# CITY OF PORTLAND, MAINE

**Project Name:** “118 on Munjoy Hill” Condominium  
12 unit residential, and 2 unit commercial, condominium  
**Project ID:** #2013-255  
**Project Address:** 118 Congress Street  
**CBL:** 16-D-2  
**Applicant:** Ed Theriault, EMT, LLC (118 Condominiums, LLC)  
**Planner:** Jean Fraser

On January 28<sup>th</sup>, 2014 the Portland Planning Board considered and approved a Level III Final Site Plan and Subdivision proposal for the construction of a 4-story 14 unit condominium building at 118 Congress Street, comprising 2 commercial units totaling approximately 1800sq ft floor area, 18 parking spaces on the ground floor to the rear of the commercial units, and 12 residential units above.

C1.0

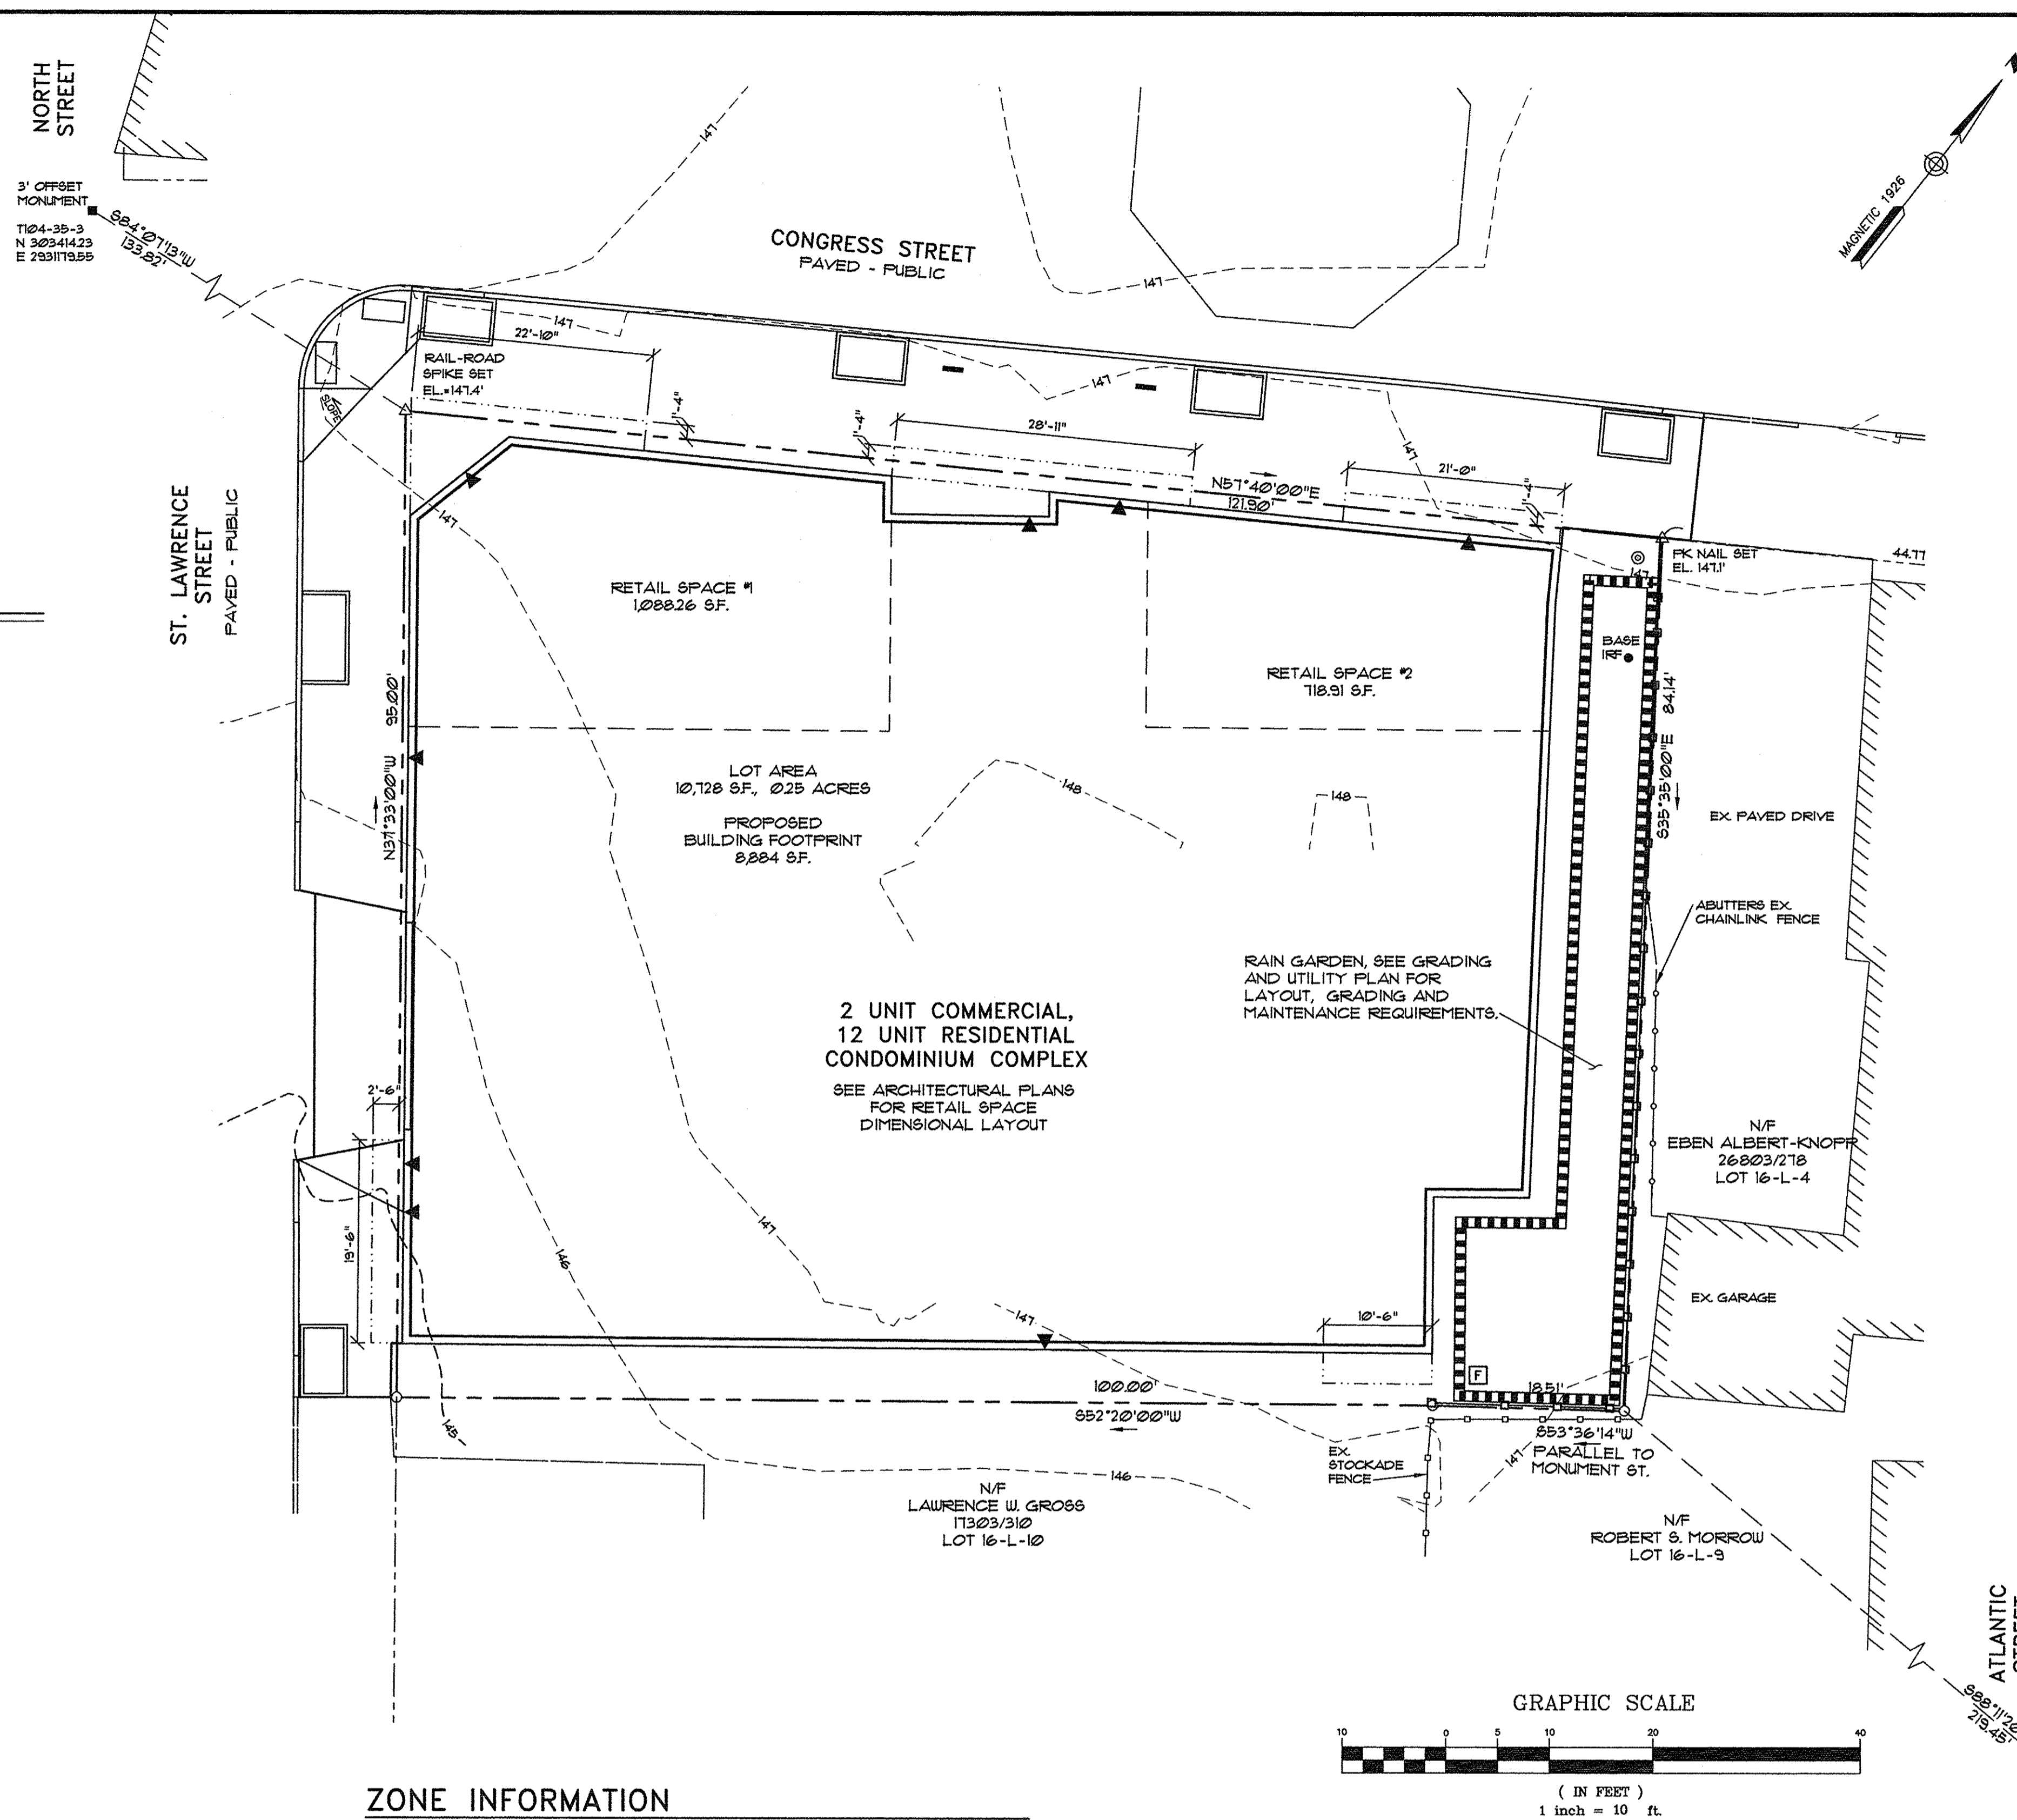
- i. That the Subdivision Plat shall be finalized to the satisfaction of the Planning Authority, Corporation Counsel, and Department of Public Services and include detailed references as advised by the Associate Corporation Counsel in e-mail dated 1.23.2014 and relevant conditions; and

Jean - I agree with your assessment. The Plat and the condo docs for this application are marginal. Although I realize that the practice has, somewhat by necessity, been to make final edits to the plat and condo docs a condition of approval, there is still a requirement that applications for subdivision approval be complete when they go before the Board and that the proposed plat and condo docs contain sufficient detail to allow the Board to make an informed decision. As you say, for this one the plat and condo docs need to be clear with respect to:

- Existence of the parking level and number of spaces and access
- Sq footage of commercial units and at least the aggregate square footage of residential
- Location of street trees
- location of raingarden (abutting Eben ALbert-Knoff property line) and ref stormwater system maintenance (confirming that this is not city and referring to agreement etc)
- more detail re overhangs over ROW
- Show all nearby buildings on plat
- Maintenance of green walls on side and rear elevations
- Existing and anticipated utilities and any associated easements
- Responsibility for general maintenance and trash and snow removal

The subdivision plat really needs to inform folks of necessary information on its face. It is not sufficient to be incorporating by reference other sheets when it comes to the essential contents of the plat. As with all applications, I direct these folks to our ordinance, which outlines what is required on all plats. Their attorney should similarly be familiar with the State statute that outlines necessary components of condominium documents.

1 CITY OF PORTLAND BRICK SIDEWALK/CURB DETAIL
L2.0 NOT TO SCALE

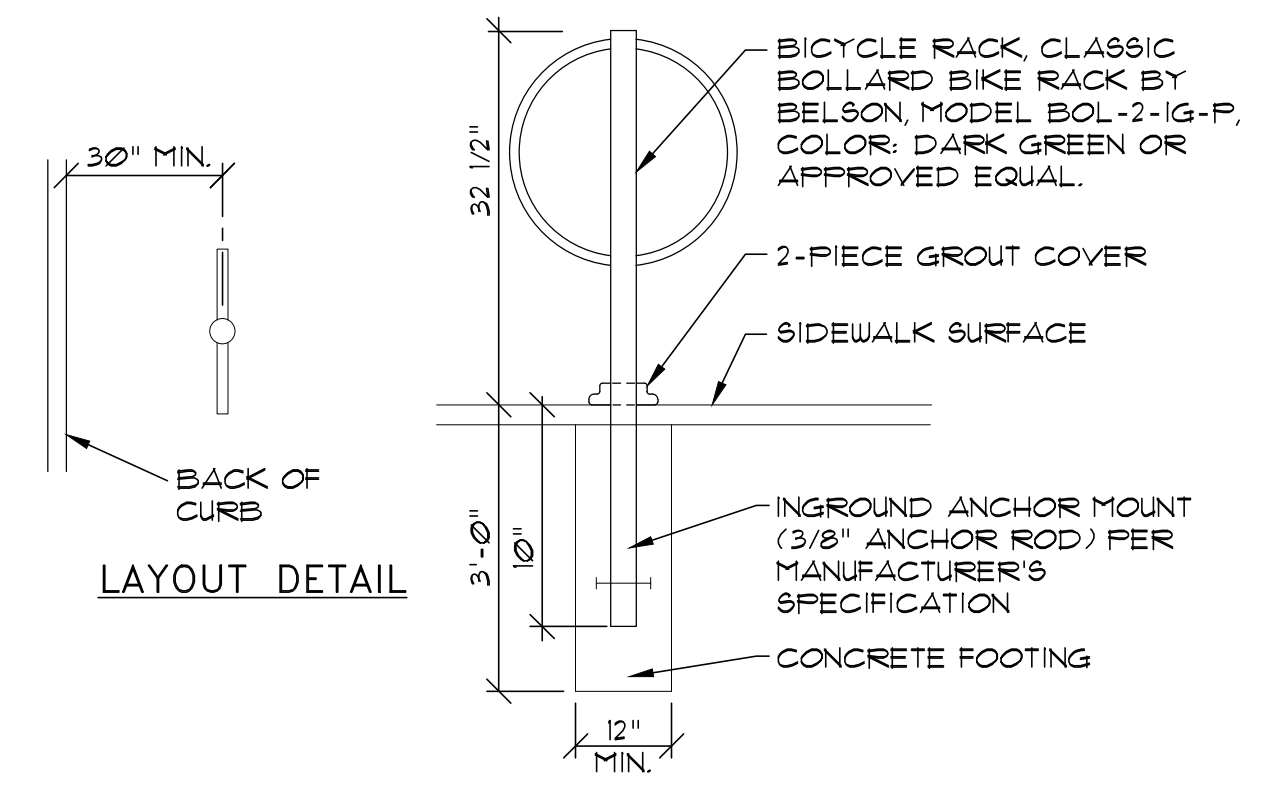
- 5) The following details for work within the City Right-of-Way should be provided in accordance with the City's Technical Manual:
  - a) Pavement Repair Cross Section detail

- b) Brick Sidewalk detail
- 6) All previous review comments have been adequately addressed.

6 RAISED GRANITE PLANTER - PLAN VIEW
L2.0 NOT TO SCALE

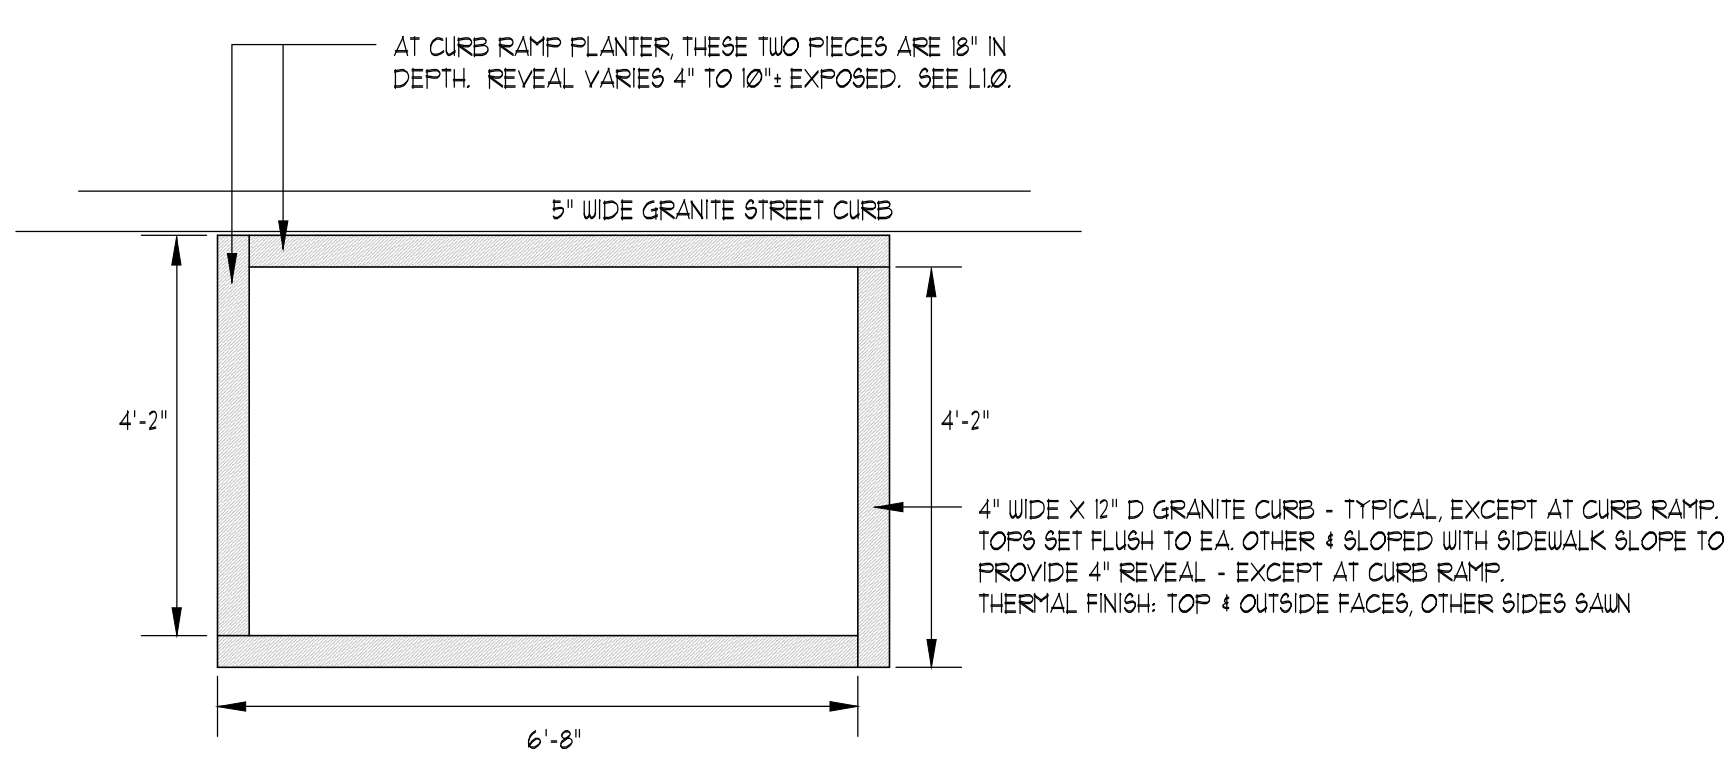
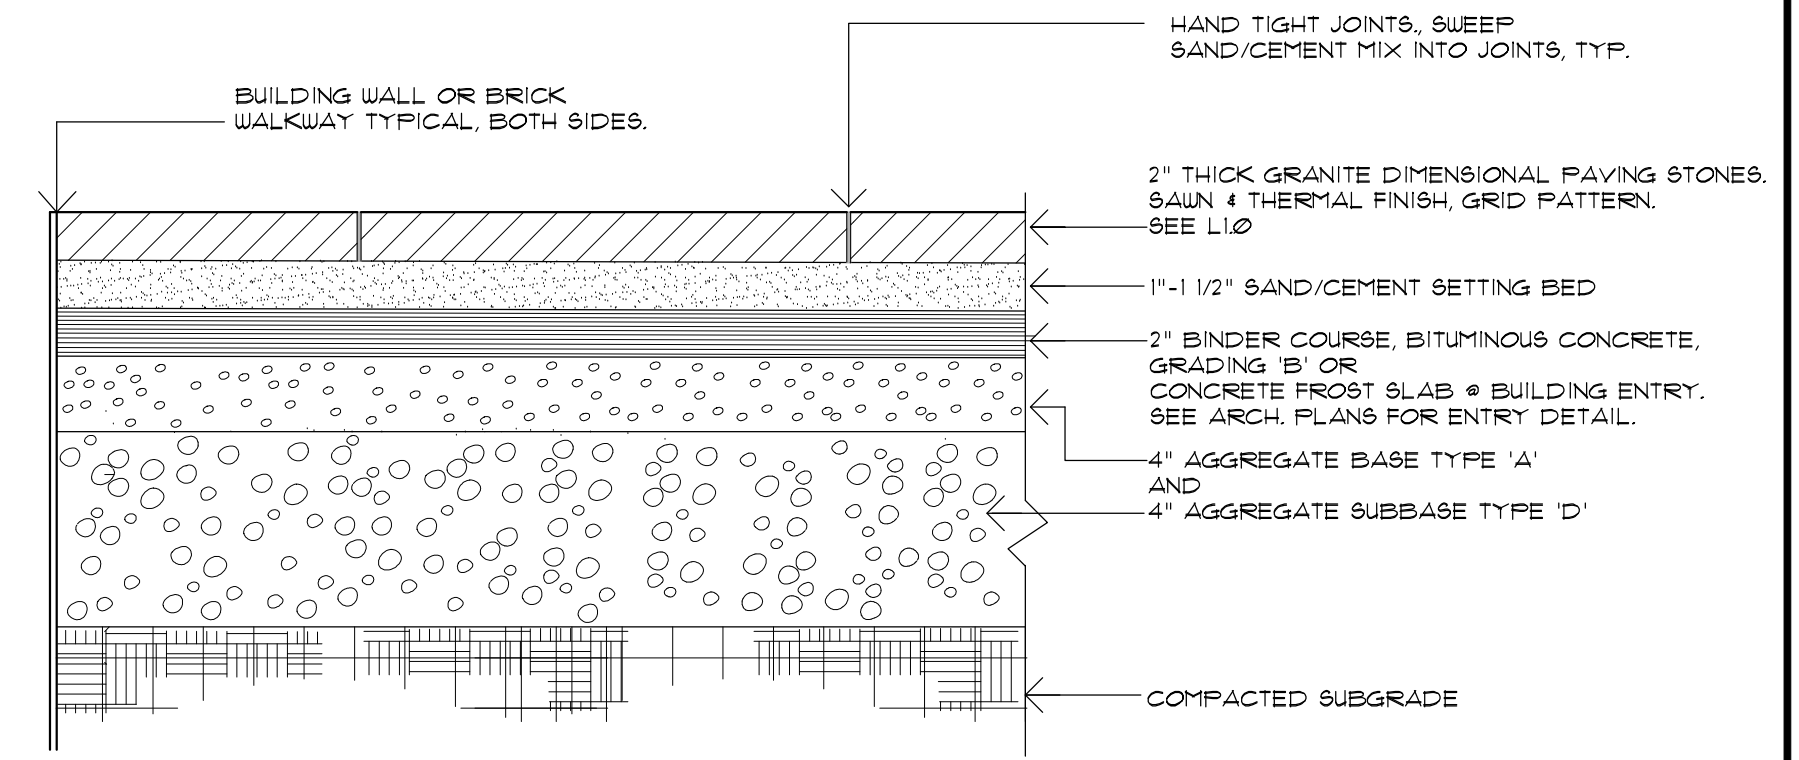
**Granite planters in right of way** - the six granite planters are proposed to be planted with street-trees and 'Cranesbill', perennial geranium. This will add interest to the typical mulched tree well. Long term however it is unlikely the city would be able to maintain these plantings. Ideally, the project could adopt the tree wells and maintain the landscape planting.
